Recommendation Report for Planning Permission for Works or Extension to a Dwelling

REF NO: Y/53/25/HH

LOCATION: Flints
Hoe Lane
Flansham
PO22 8NP

PROPOSAL: Part single, part two storey rear extension, dormer extension and alterations to fenestration.

Proposed Ground Floor Plan

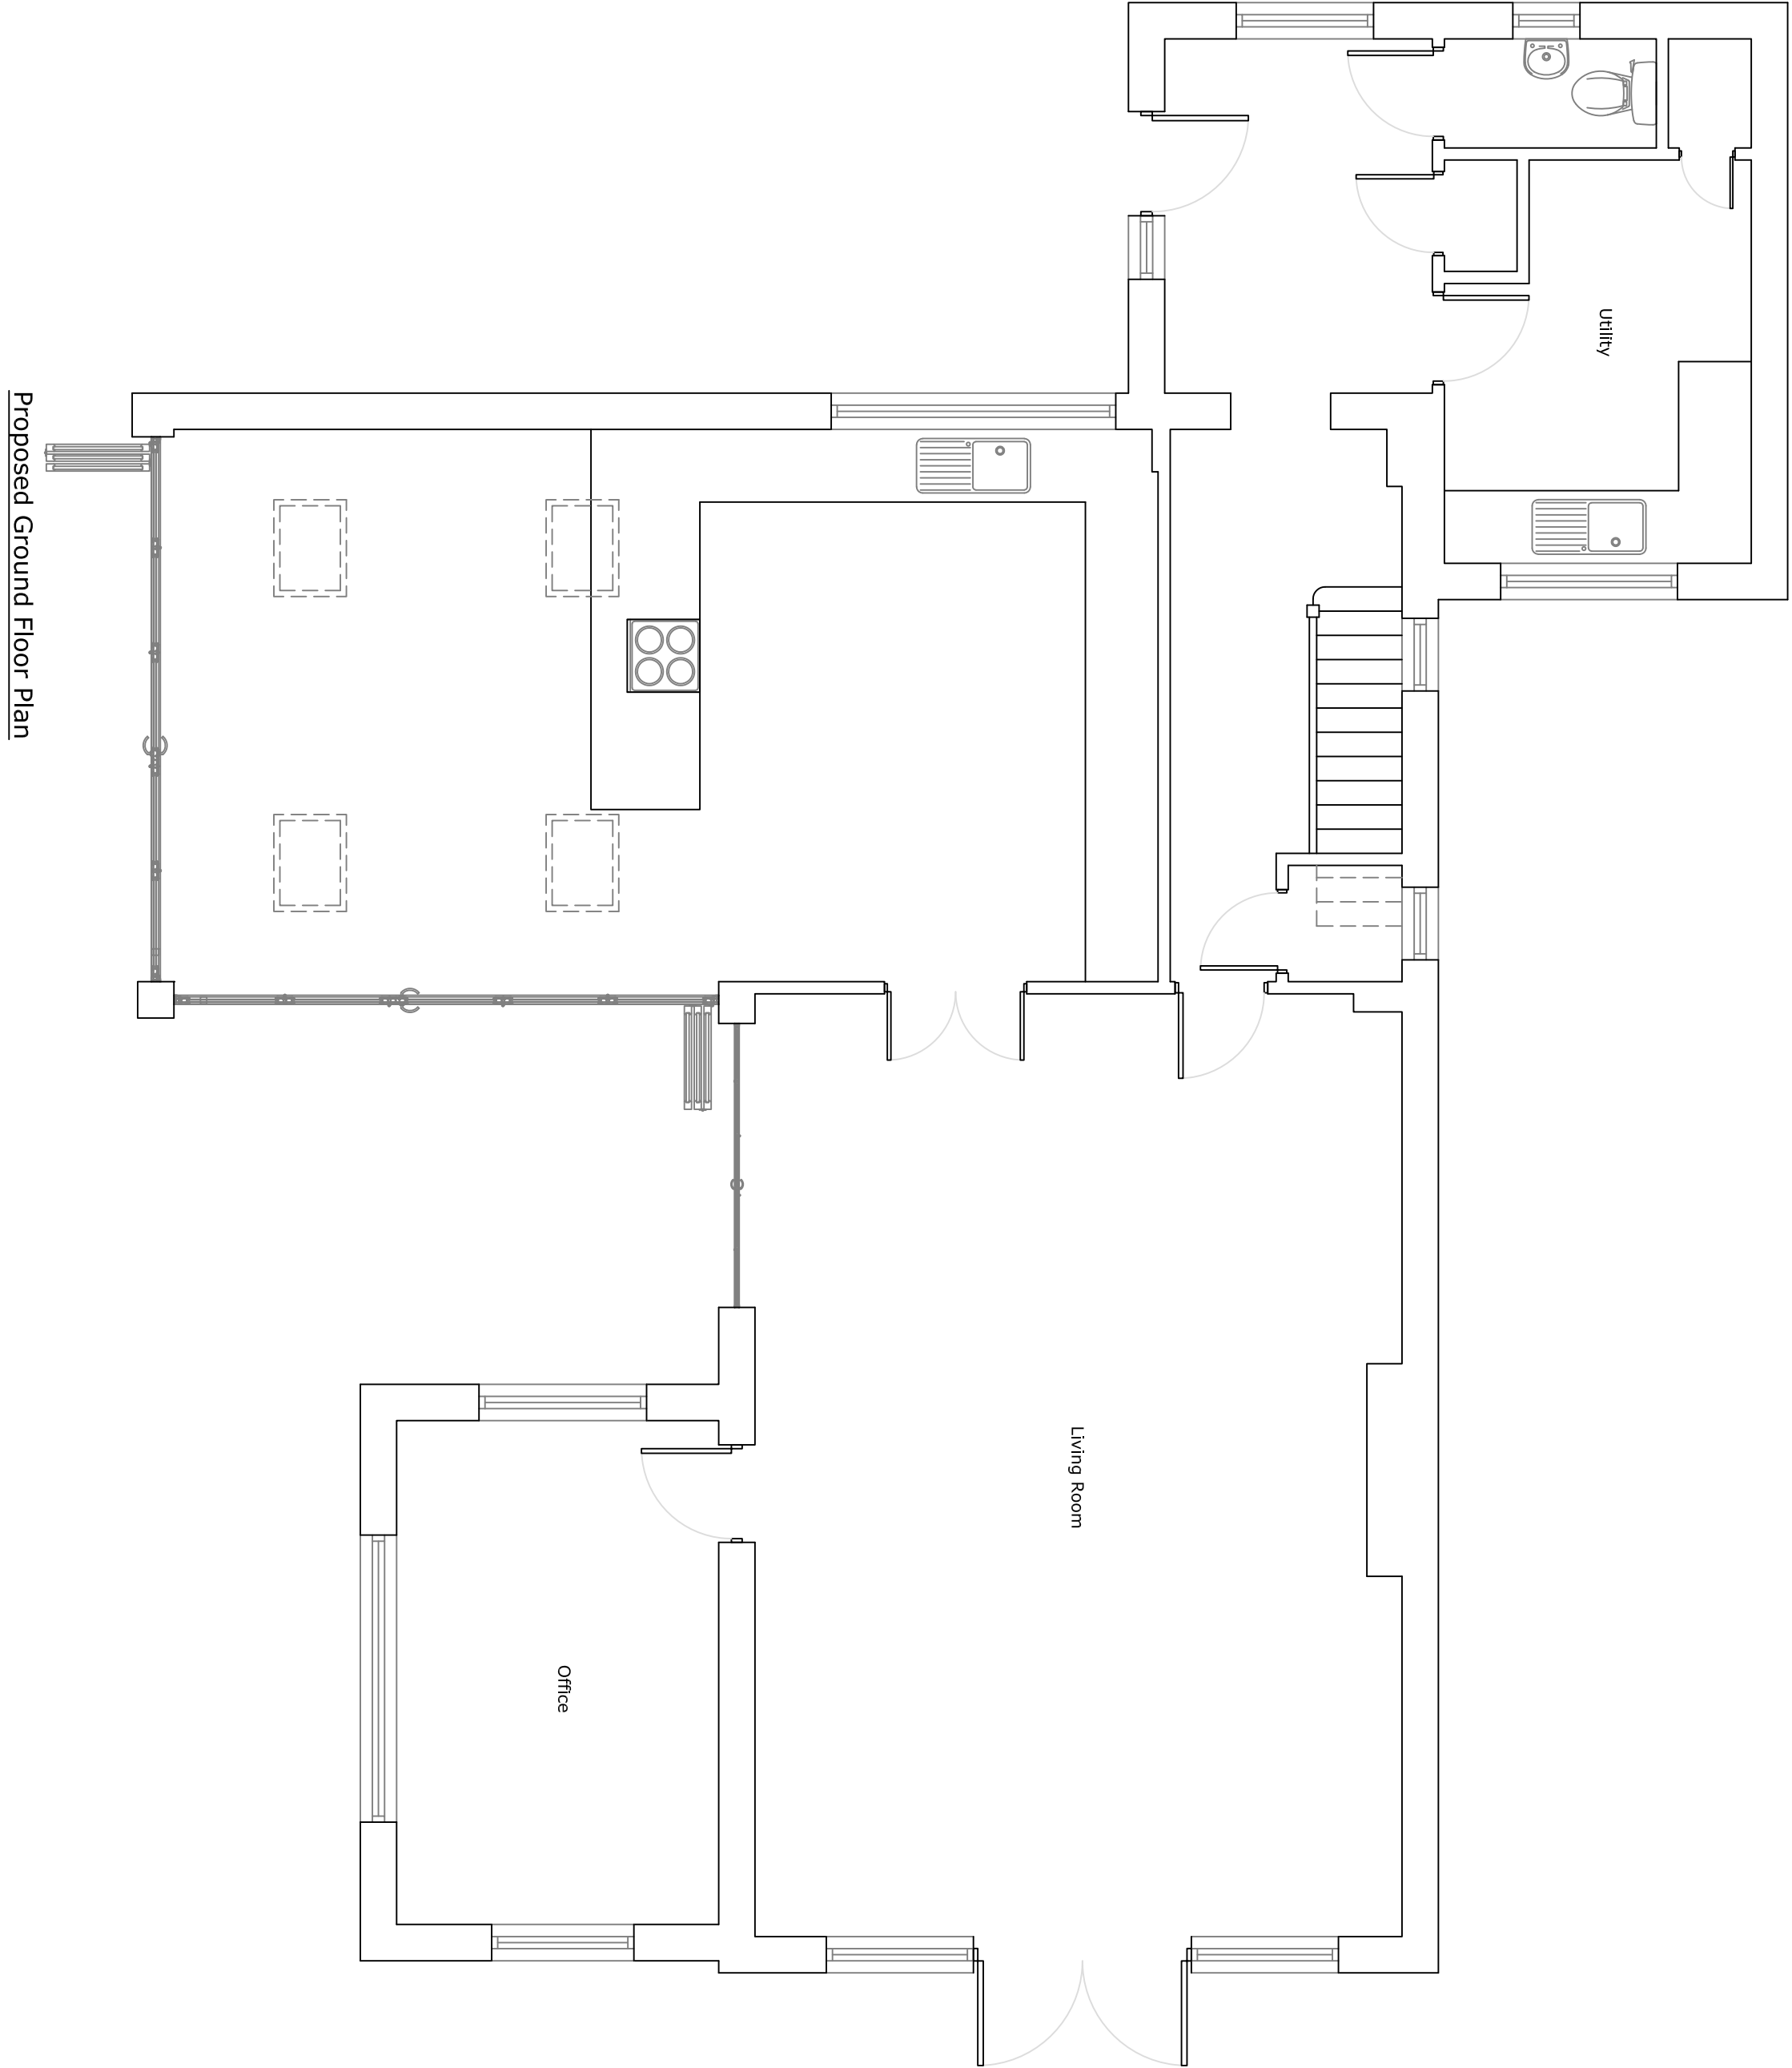
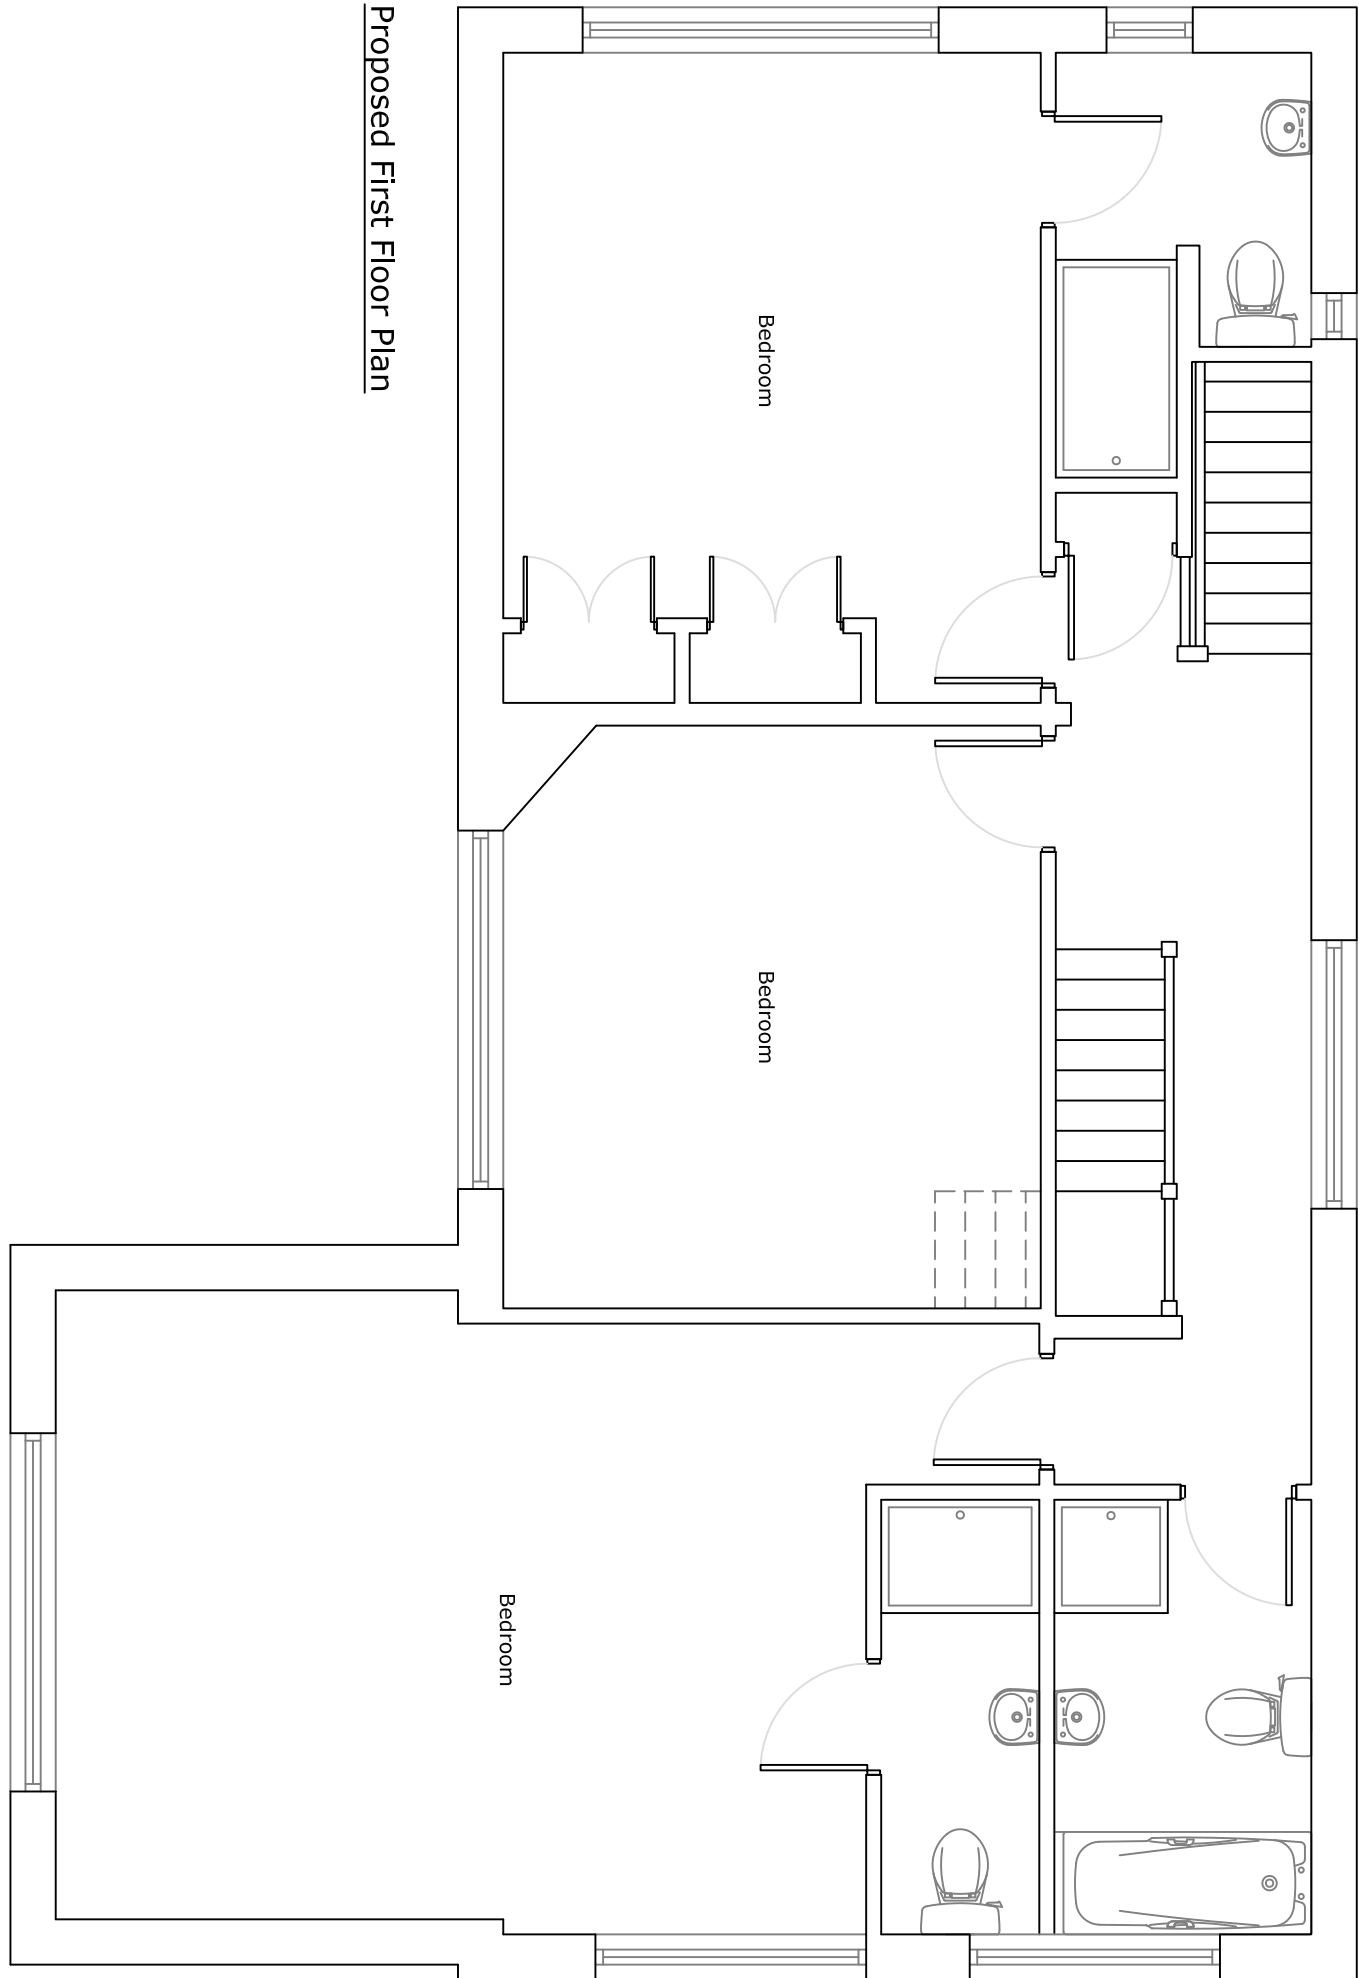
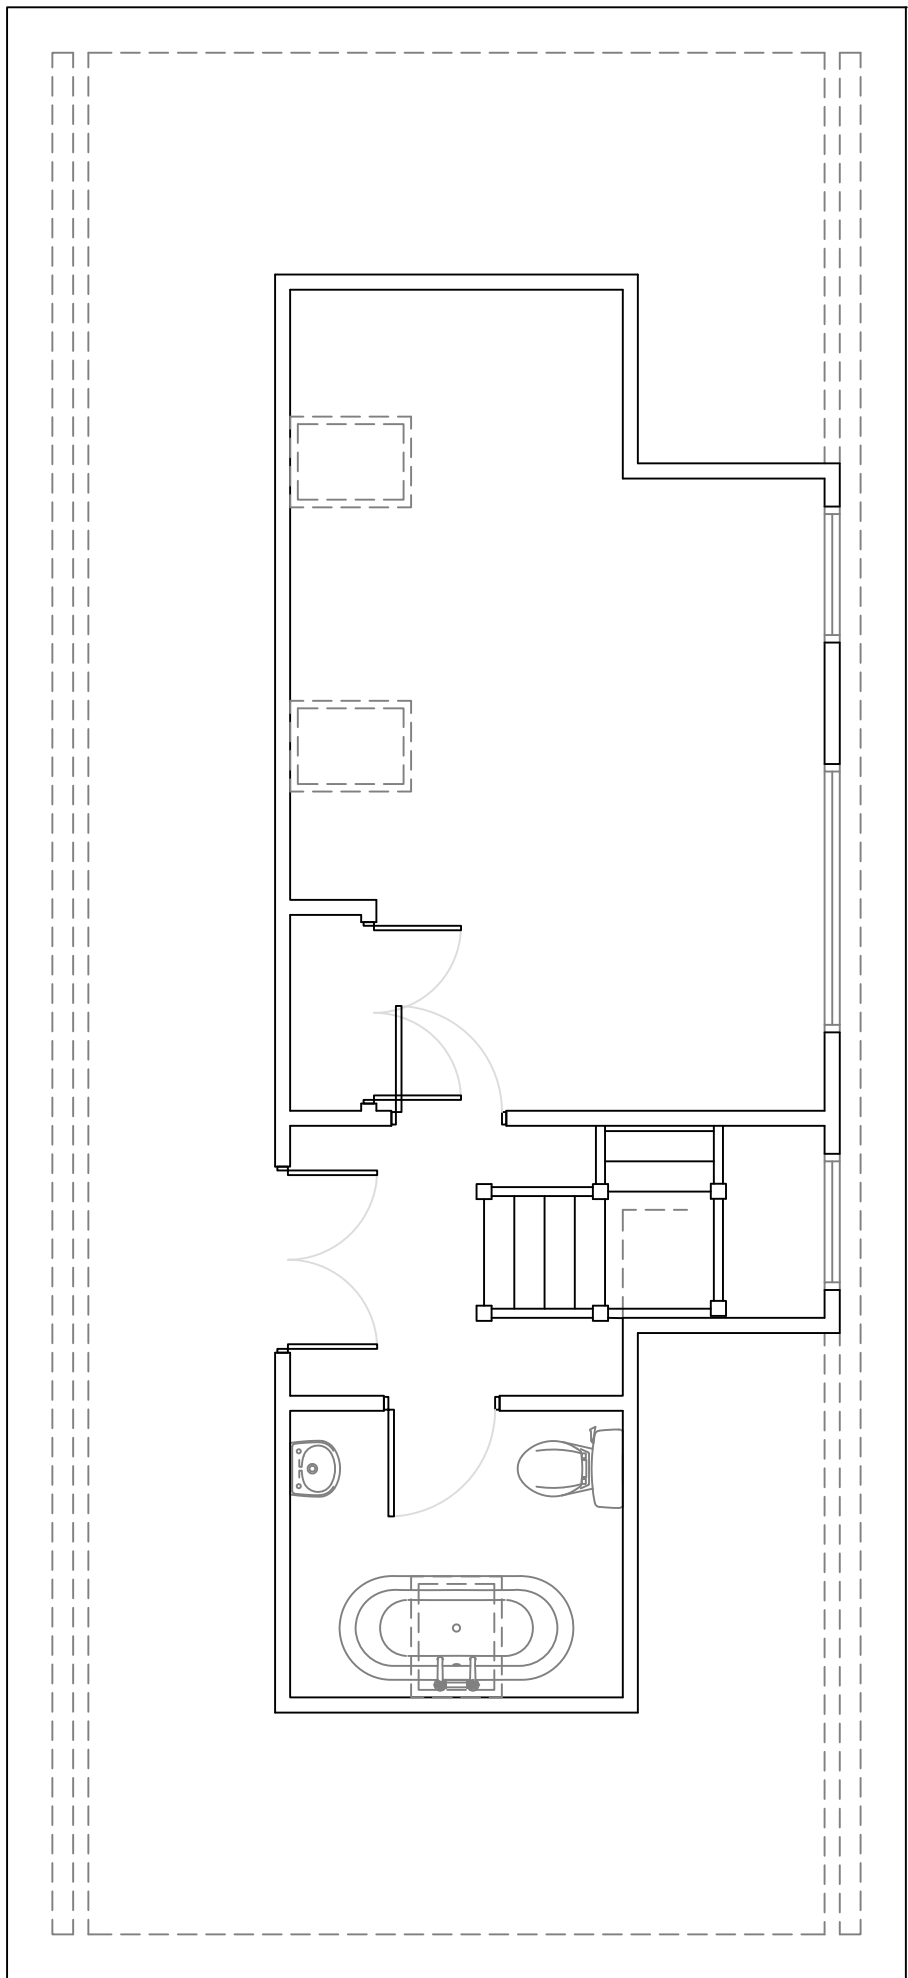
The proposed single storey extension would measure 5m in width, 4.7m in depth, with a maximum height of 4.4m and eaves height of 2.3m. It would feature a gable end with large windows. Whilst this extension would have a more modern appearance than the host dwelling, it is subservient and would not appear prominent within the street scene of Hoe Lane, reducing any harm to the character of the area.

The first floor extension would measure 4.7m in width, 3m in depth and would match the eaves height of the host dwelling. The first floor extension would increase the bulk and massing of the roof form, although it would not exceed the existing ridge height. The first floor extension would replace an existing catslide roof form, however the hipped roof form of the first floor extension would reflect the character and appearance of the host dwelling and the proposal would be of a size and scale that would be a subservient addition to the host dwelling. The proposed first floor extension would not result in harm to the visual amenity of the host dwelling, street scene or wider area.

The rear dormer would measure 5.7m in width and 2.1m in depth, with a flat roof with a height of 2.2m. There is an existing smaller dormer which the proposed would replace in a similar location on the west (rear) roof slope. Part M of the Arun Design Guide (ADG) requires dormers to be minor incidents in the roof plane and centrally located as to not damage the original character and appearance of the building and its surrounding area, incorporating pitched roof in most cases. While the proposed rear dormer features a flat roof design, it is sited to the rear and would not be visible from the street scene. The dormer would be set in from the flank elevations, set up from the eaves and set down from the ridge height and would not result in harm to the visual amenity of the host dwelling.
